**Subject:** 3744 HAZARs Comments EIS, Maryvale Solar Farm, Modification No.1 (SSD-8777-Mod-1).

Thanks for forwarding the Modification Report for the Maryvale Solar Farm, Modification No.1 (SSD-8777-Mod-1). The proposed modification is for a Battery Energy Storage System (BESS) having peak discharge capacity 125MW and a total storage capacity of 375MWh. The BESS technology being proposed is utility scale lithium batteries. Two alternative strategies for the BESS installation have been proposed. The first is for a centralised BESS and the second is for a distribution of the BESS sub-units throughout the site. The approved development did not include a BESS.

1. Maryvale Solar Farm, Modification Application, Development Consent SD 8777, Energy Forms, Version 3, 19 January 2021;
2. Preliminary Hazard Analysis for Maryvale Solar Farm Battery Energy Storage System, Planager, Revision 2, 19 January 2021.

CENTRALISED BATTERY ENERGY STORAGE SYSTEM(BESS) FORMAT

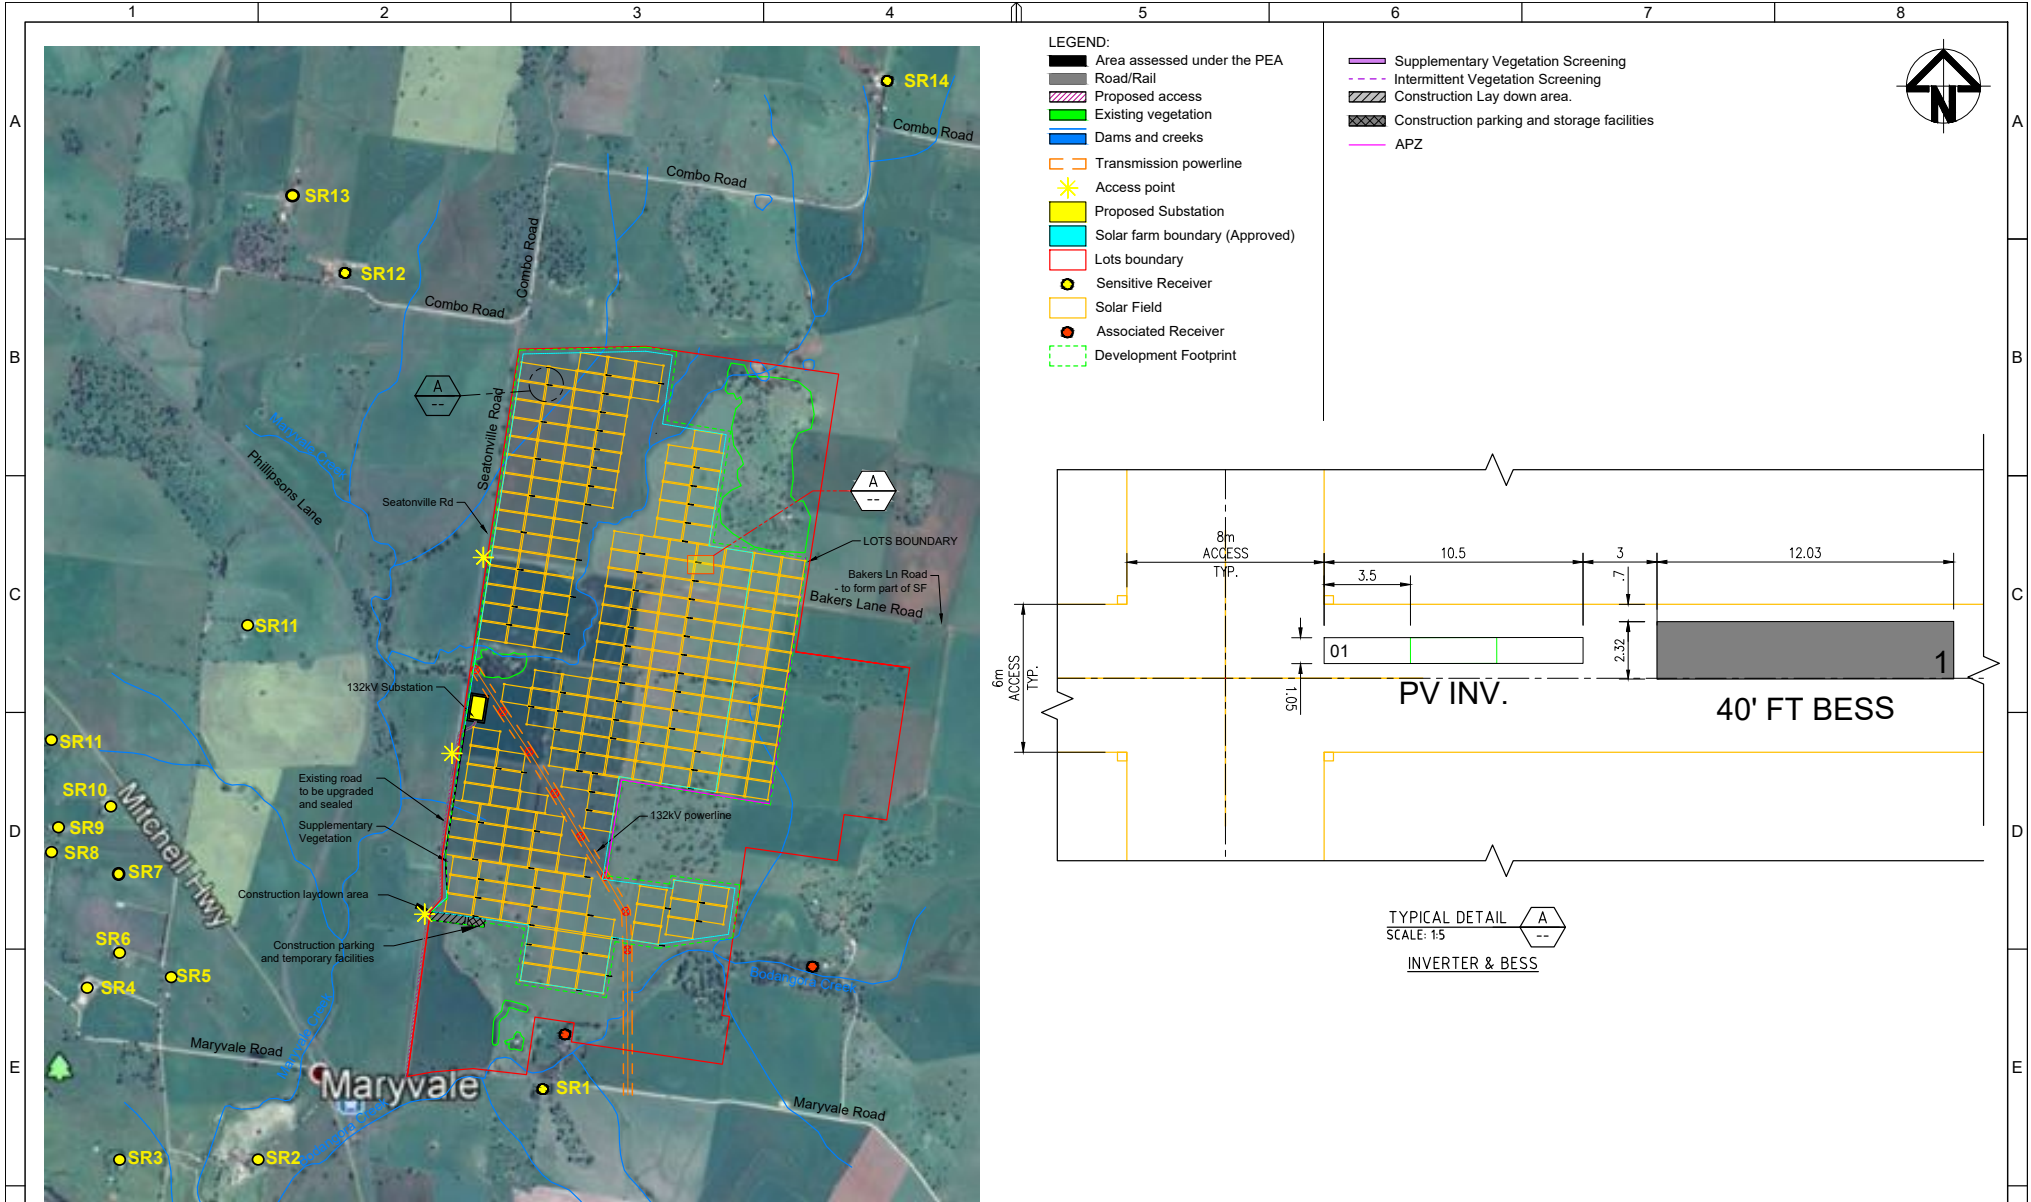
We agree that the layout that the proposed centralised BESS will be contained within the footprint allocated, with adequate separation between battery enclosures and separation from adjacent land users. As such the layout of the centralised BESS is satisfactory to meet the qualitative risk criteria in HIPAP No.4 with the implementation of codes and standards applicable to BESSs.

Figure 5: Project Area layout - Format 2 Distributed BESS Option

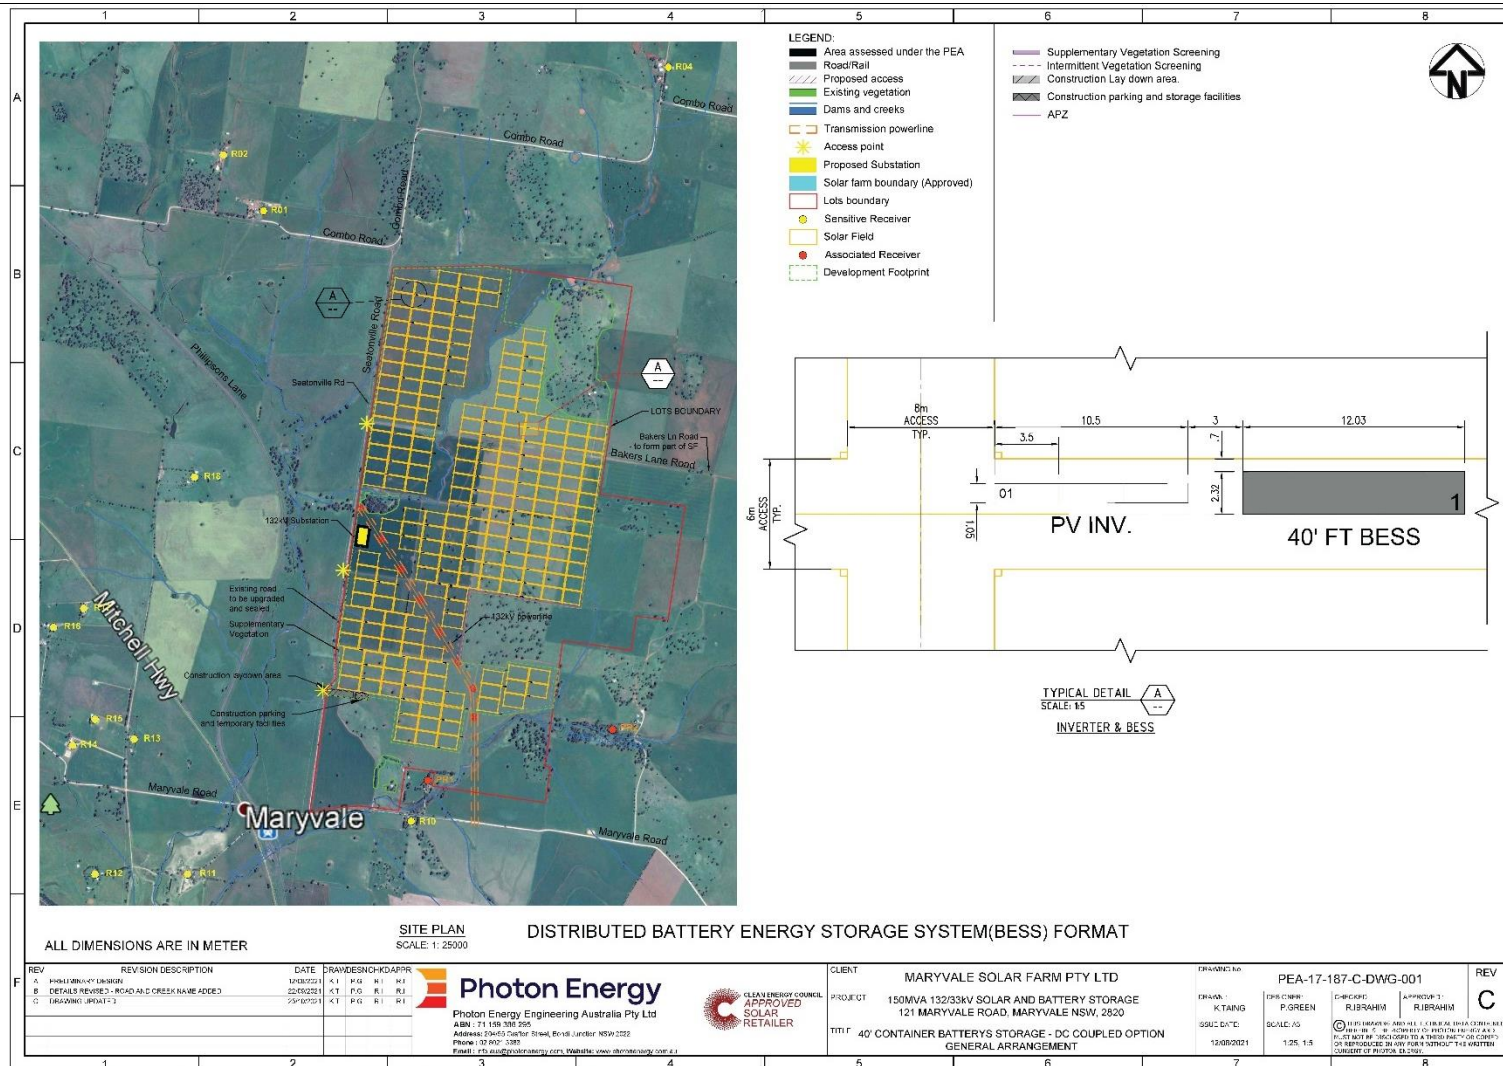
The implementation of a dispersed BESS will provide adequate separation between battery enclosures and separation from adjacent land users and is satisfactory to meet the qualitative risk criteria in HIPAP No.4.
